Operational Traffic Management Plan

Horsley Drive Business Park Stage 2
May 2022

Drawing Number:
AG01

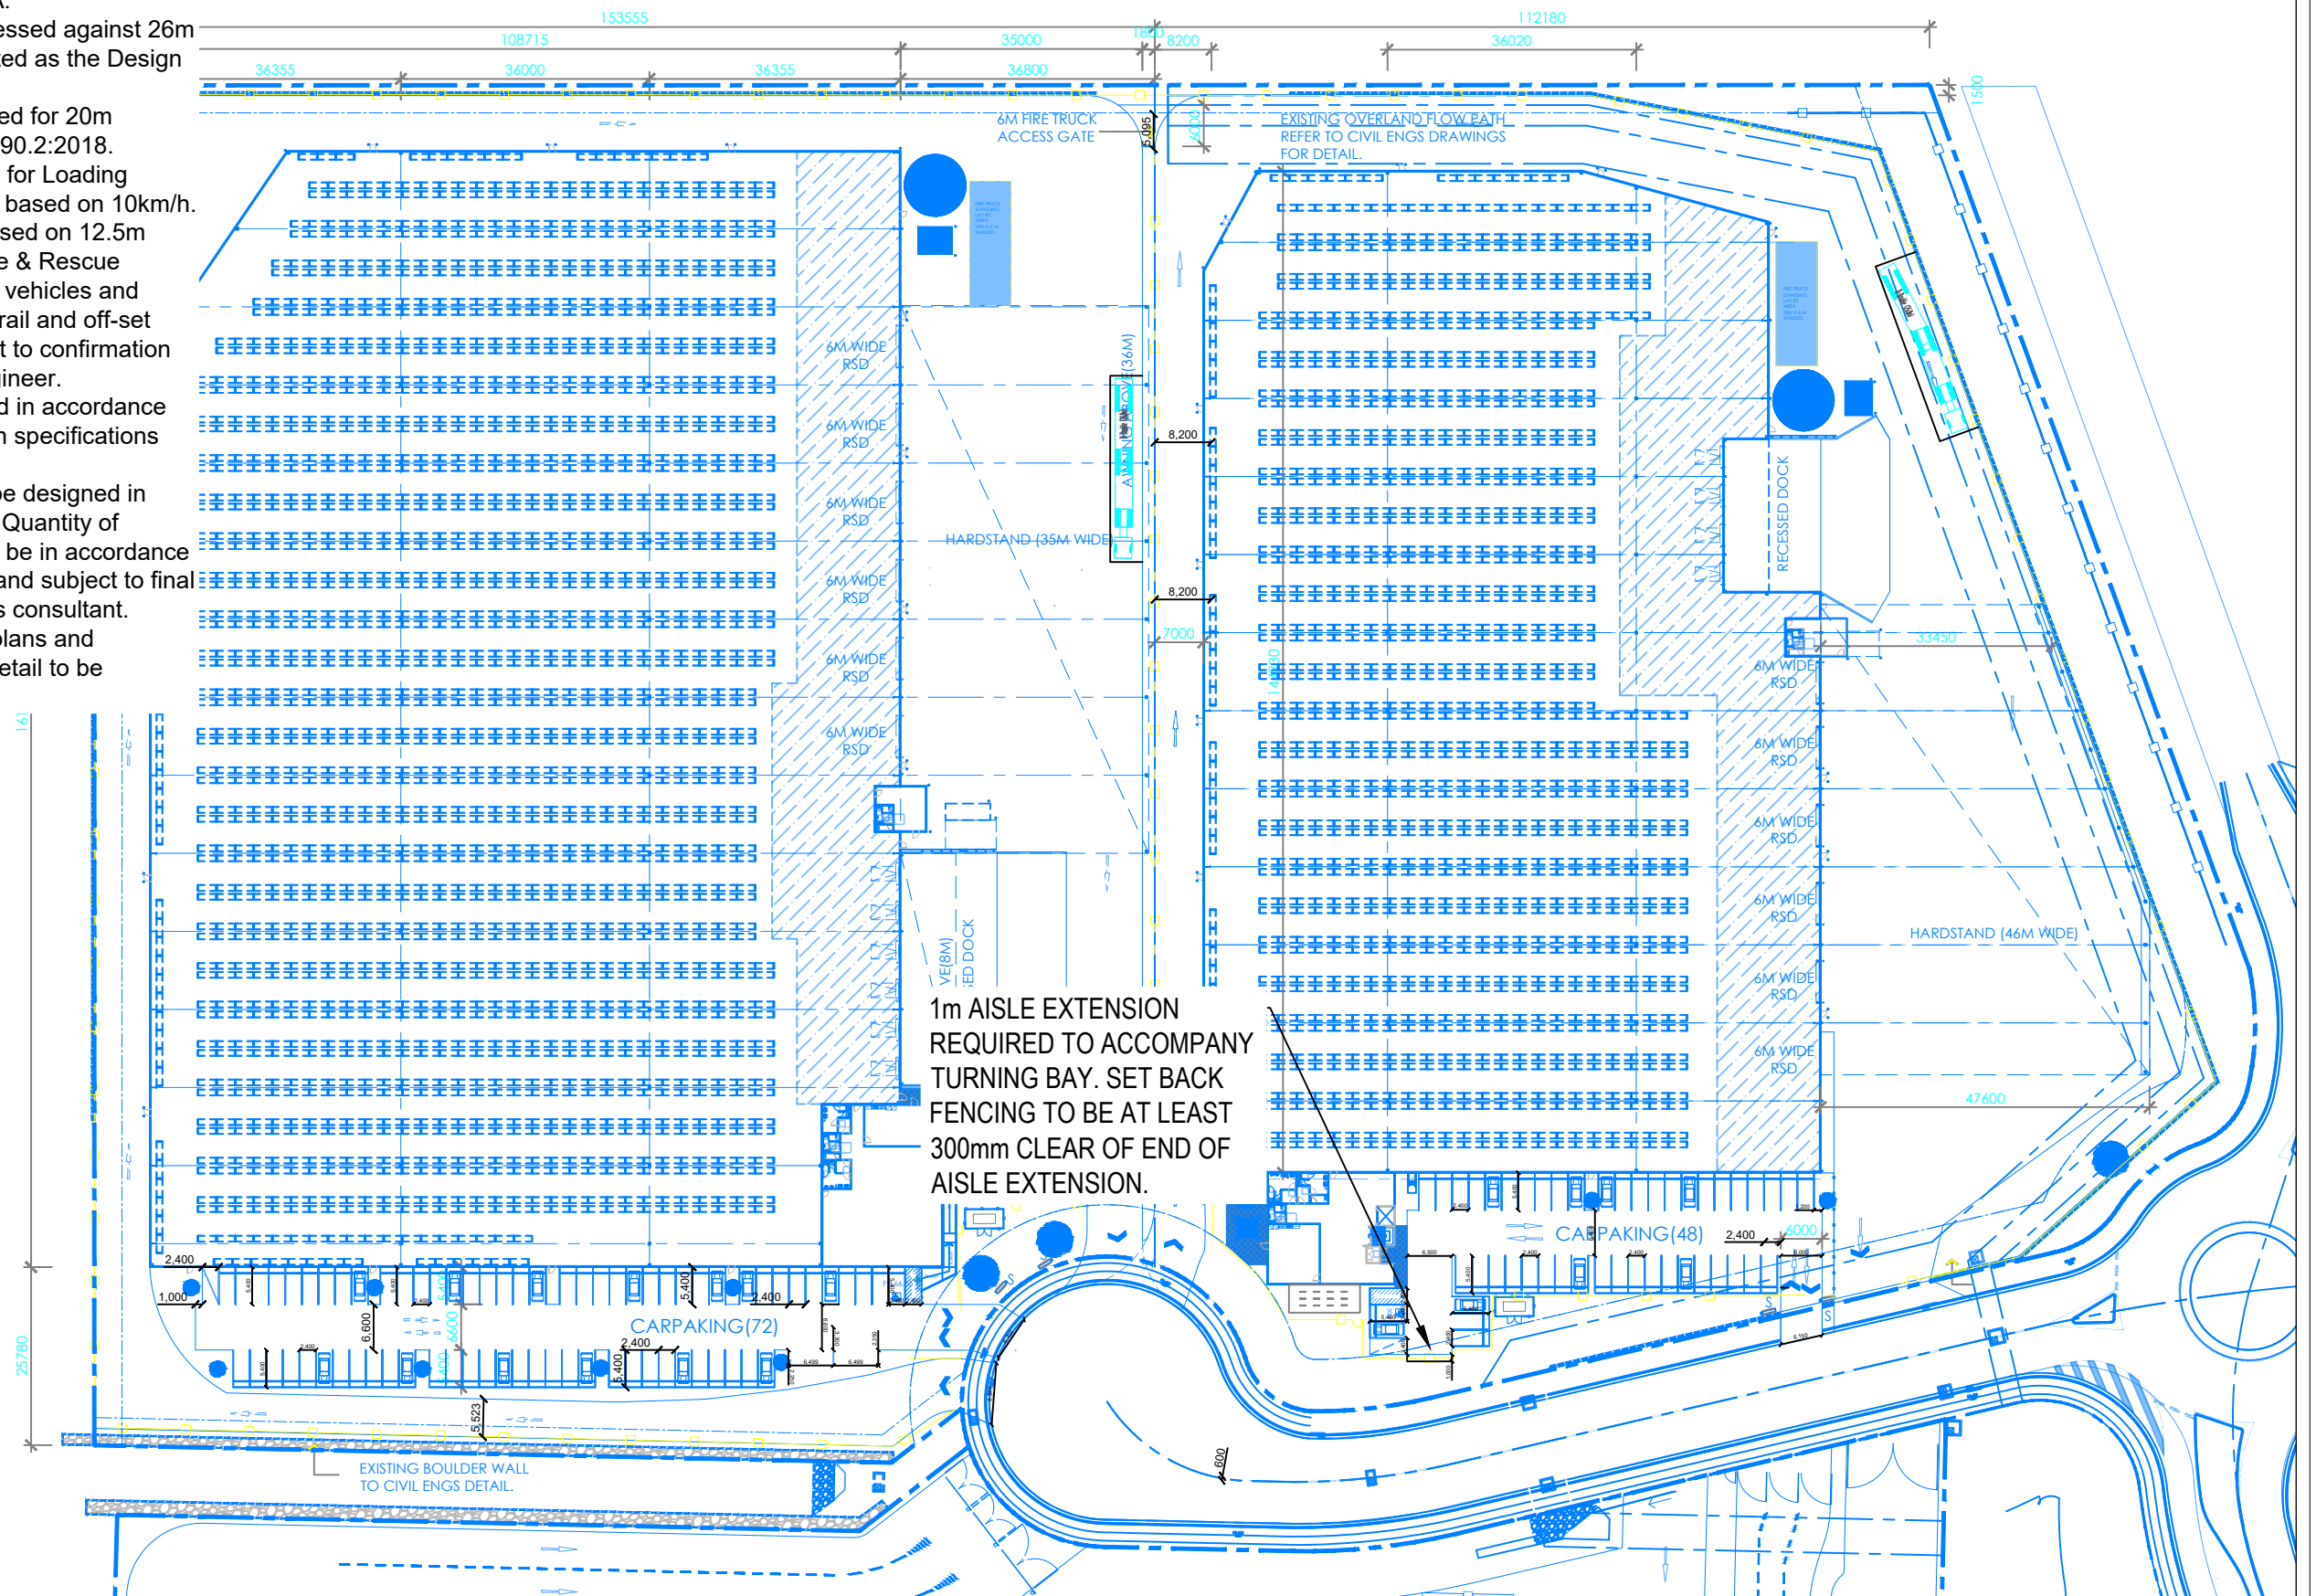
Item No.	Description	Relevant Section of TA
39	Movement conflicts identified for Warehouse 3 (B-double turn path) and potentially Warehouse 2. Design needs to be amended or justified (including loading dock management plan) if design not revised to eliminate movement conflicts.	As discussed in Section 8.3, the generation of trucks anticipated to be generated by Warehouse 3 is minimal, with 7 two-way movements anticipated during the peak hour (i.e. 3-4 trucks). Therefore, the instances of large vehicles passing each in this location

would be rare. As such, implementing management measures is deemed entirely appropriate. The management measures implemented will be developed during the detailed design stage and implemented prior to occupation and will include items such as signage, convex mirrors and detector activated flashing amber lights. It is anticipated that this could be ensured via a suitable Condition of Consent. Warehouse 2 is proposed with one-way circulation and as such no such conflicts exist.
40	All loading docks and any parking / unloading areas not within the loading dock area for both Warehouses should be shown as occupied in all turning path overlays.	Refer to Appendix A for updated swept path analysis. It is worthy of note here that in practice, it is rare that all docks occupied at the same time, which allows for the easy management of docks.
41	Reversing movements shown only for 19m semi-trailer – not 26m B-Double, which has not been explained or justified in TIA. Reversing and pull away movements should be provided for the northern and two southern loading bays for Warehouse 2, the recessed dock for Warehouse 3 and northern 6m wide RSD for Warehouse 3 whilst noting requirement above to show loading docks / parking areas as occupied.	The development has not been designed to accommodate reversing b-double movements. B-double vehicles have been adopted as a check vehicle only, with the design vehicle being a 20m AV, as per Section 8.2. The volume of b-doubles accessing the Site is anticipated to be very low frequency and hence it has been has adopted as the check vehicle for design purposes. Unless specifically required, it is standard practice to design spec warehouse developments to either allow for unhitching of b-doubles and then manoeuvring into the required dock, OR b-doubles are to be side loaded. This will ultimately depend on the requirements of the end user (which is not know at this stage), who will be subject to a Loading Dock Management Plan. It is anticipated that side loading would be the preferred arrangement by almost all of the future tenants as it presents a more efficient option. Nevertheless, in the instance of a b-double uncoupling, the rear trailer would be unhitched and left within the unhitching area. The prime mover would then manoeuvre the first trailer as required. The prime mover would then manoeuvre the rear trailer to the relevant areas to be loaded / unloaded as required.

It is understood that a draft version of the LDMP will be developed prior to construction. However, it is noted that the final LDMP will need to be implemented prior to occupation. For the purposes of the SSDA assessment, it has been demonstrated that a b-double can access the Site and turn around appropriately. The particular arrangements within the Site will ultimately be subject to the future occupiers needs. However, it is noted that all occupiers of the Site will be required to operate as the per NSW's Safe Work requirements. The critical manoeuvres have been shown in Appendix A.
42	Warehouse 2 indicated two loading docks limited to HRVs only but shows 19m semi-trailer.	The HRV swept path analysis for the southernmost dock referenced is shown on AG04 in Appendix A. the swept of the semi-trailer was shown only to demonstrate the movement and why it requires restriction. For clarity, Appendix A has been updated to demonstrate the HRV movement only.

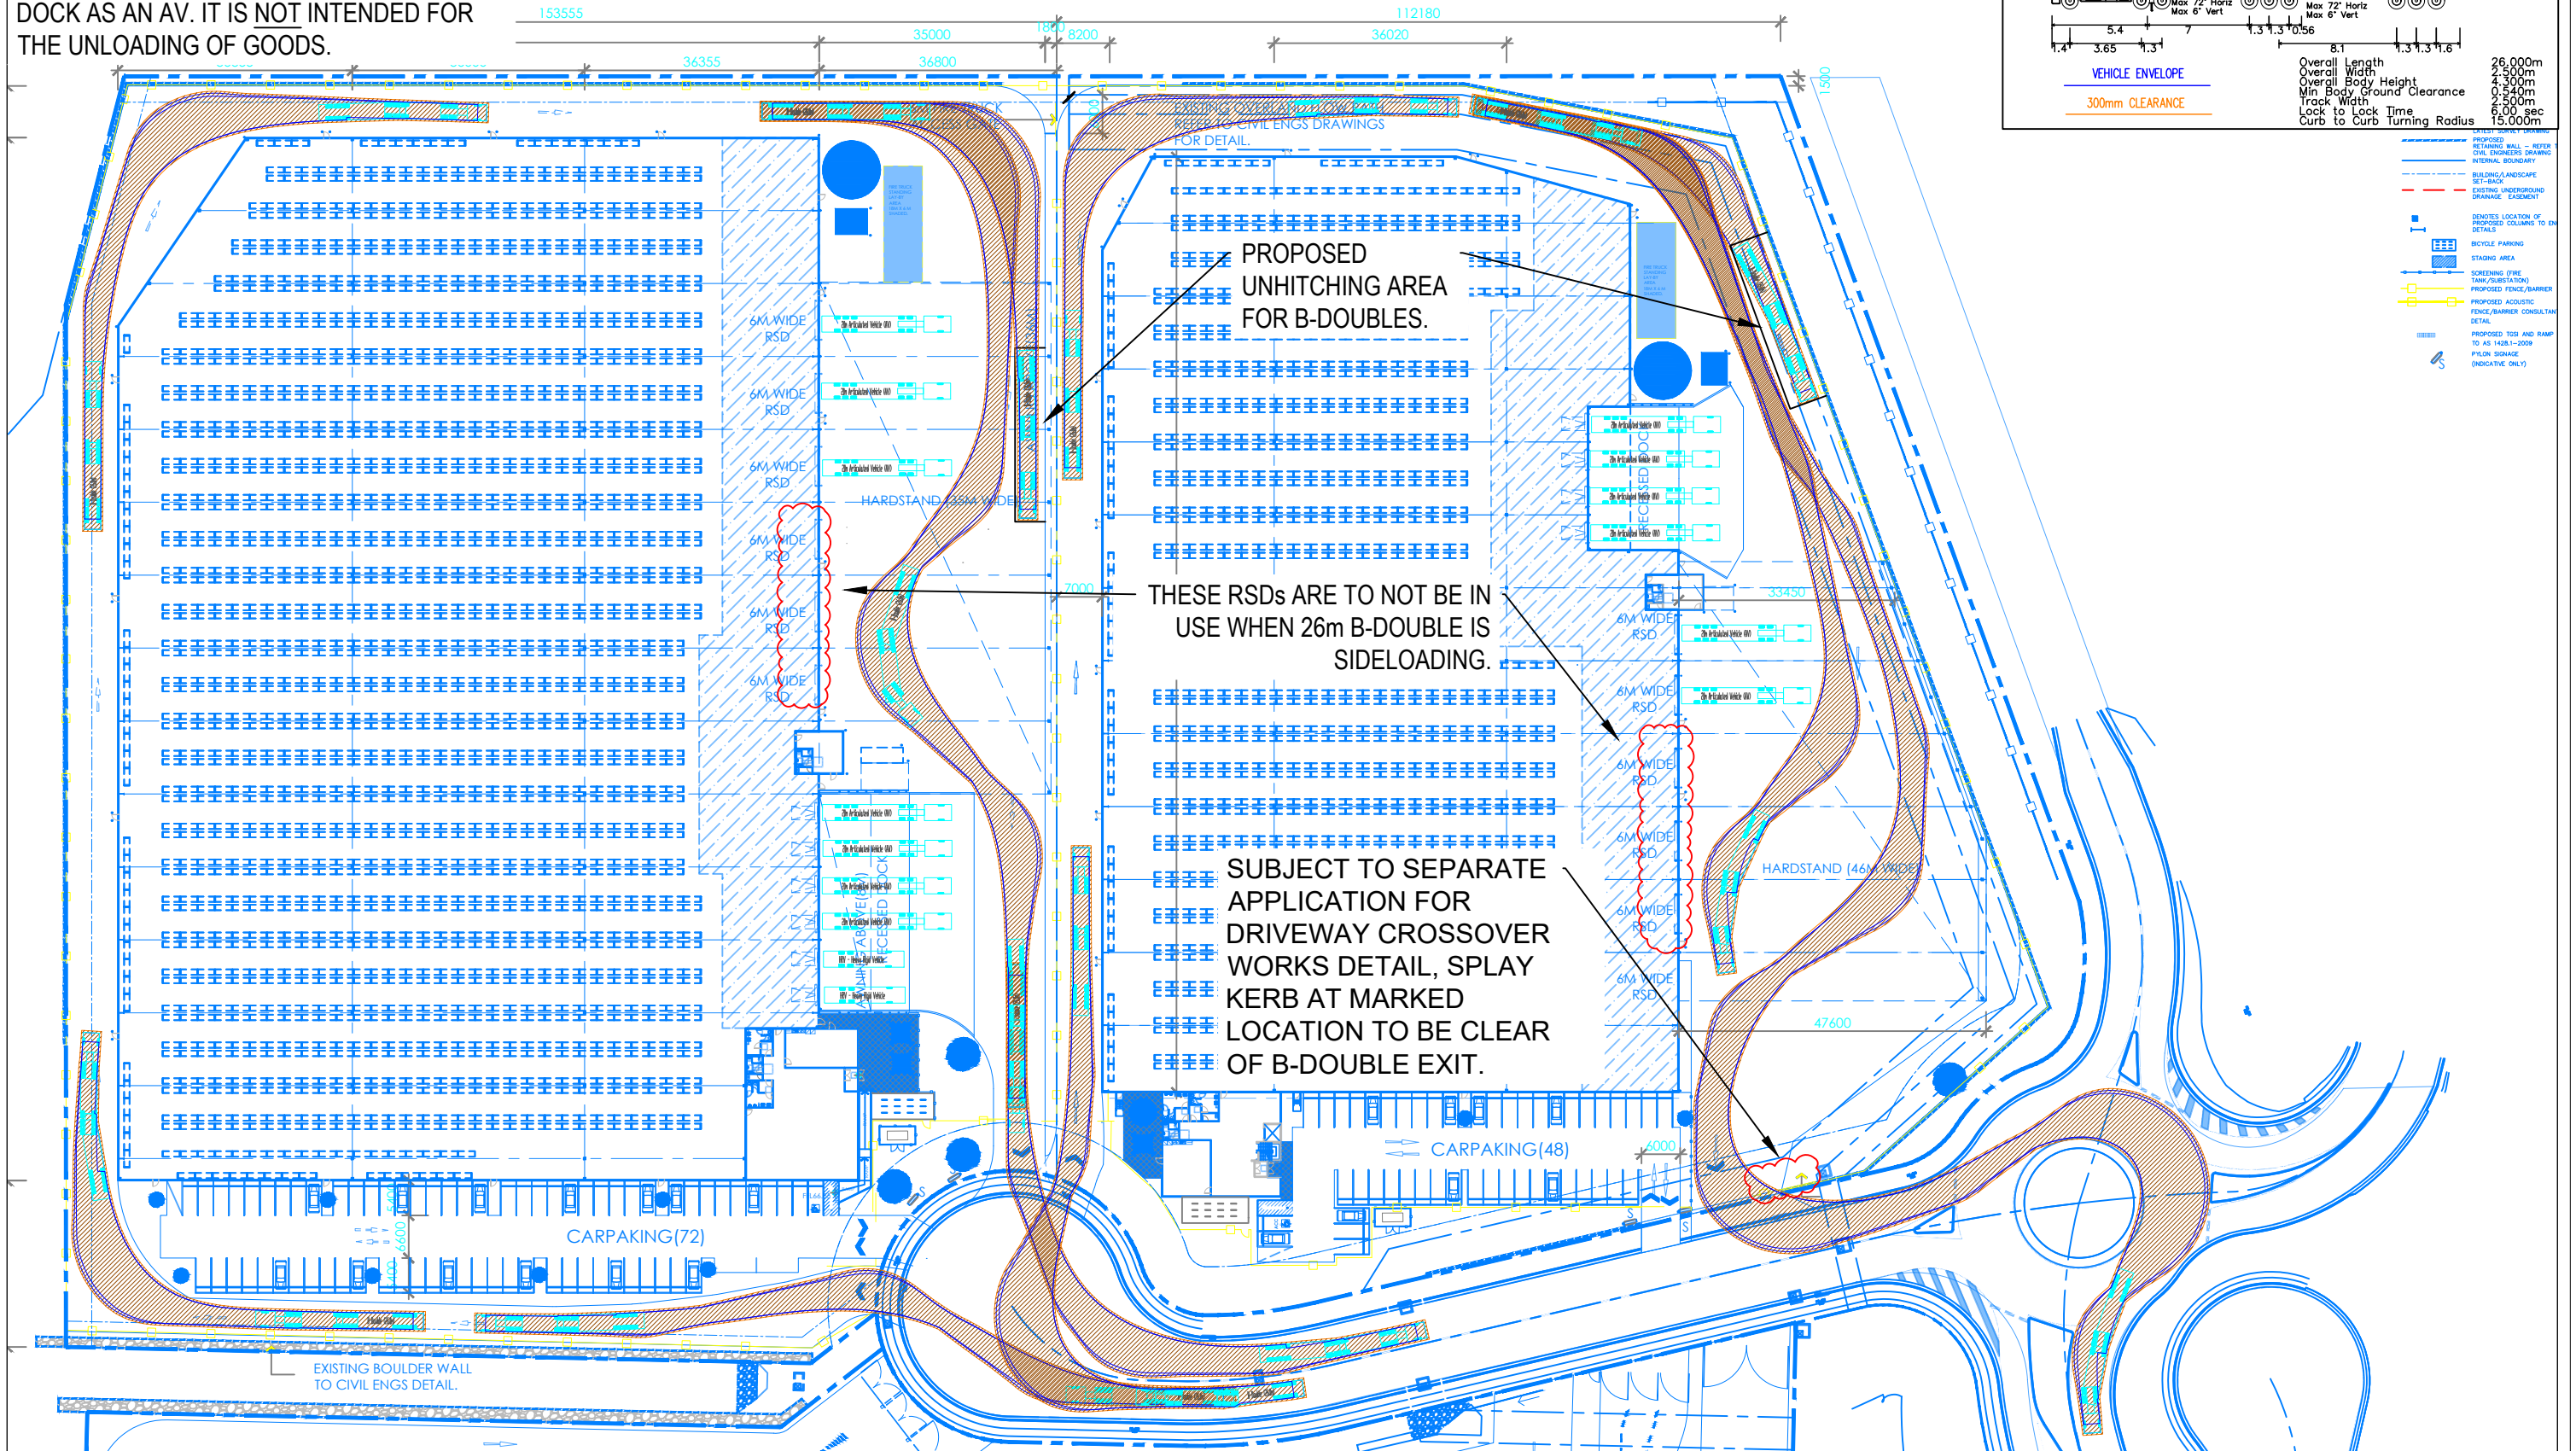
Item No.	Description	Relevant Section of TA
16.	Loading Dock Management Plan (LDMP) states that B-Doubles will be side loaded. The swept path analysis provided in the TA do not appear to provide adequate space within the designated 'unhitching area' (which is also understood to be the designated loading / unloading area without unhitching occurring) to permit a forklift to operate on the eastern side of the trailers for both Building 2 and 3. The Department understands that curtain side trailers are generally required to be loaded / unloaded from both sides.	Please see section 3.2 and 4.2 which have been amended to address this. It is not intended for the B-doubles to be side unloaded within the unhitching areas. Instead they can be side unloaded by parking parallel to 3 on-grade docks. This allows for unloading from both sides (if required) without impacting on internal traffic flow.

17.	Section 2.2 – states that unhitching of B-Doubles may occur to allow trailers to be manoeuvred into the loading docks. A detailed explanation / process of how this happens and how long it takes is to be provided. For example, is the whole B-Double reversed into the loading docks and the rear trailer disconnected with the front	Detailed unhitching procedures will be developed by specific tenants and operators. Generally the procedure would be that a B-double would park in the designated unhitching area and unhitch their rear trailer before docking as per a standard semi-trailer configuration. Once the first trailer is unloaded

trailer reversed into a separate dock? If the whole B-Double is reversed, then appropriate swept paths will need to be provided for both buildings.	the B-double is to return to the hitching area and unhitch the prime mover and hitch it onto the rear trailer before proceeding to a dock face for unloading/loading. The dock traffic controller, within the dock office is to co-ordinate these movements with the other trucks. Section 3.2 and 4.2 have been updated with this information.
18	Section 4.2 – dot point 4 states that ‘trucks entering the site must give way to trucks exiting’. It is not acceptable to have heavy vehicles queuing on the estate road and the design of Building 3 is to be amended to not create a traffic conflict zone at the site entrance as is currently the case. The Department notes that Condition B2(c) of SSD-7664 states ‘vehicles must not queue on the public road network’.	Warehouse 3 site layout has been amended to allow for separate truck entry and exit with one way flow around the site. This change removes the give way requirement.
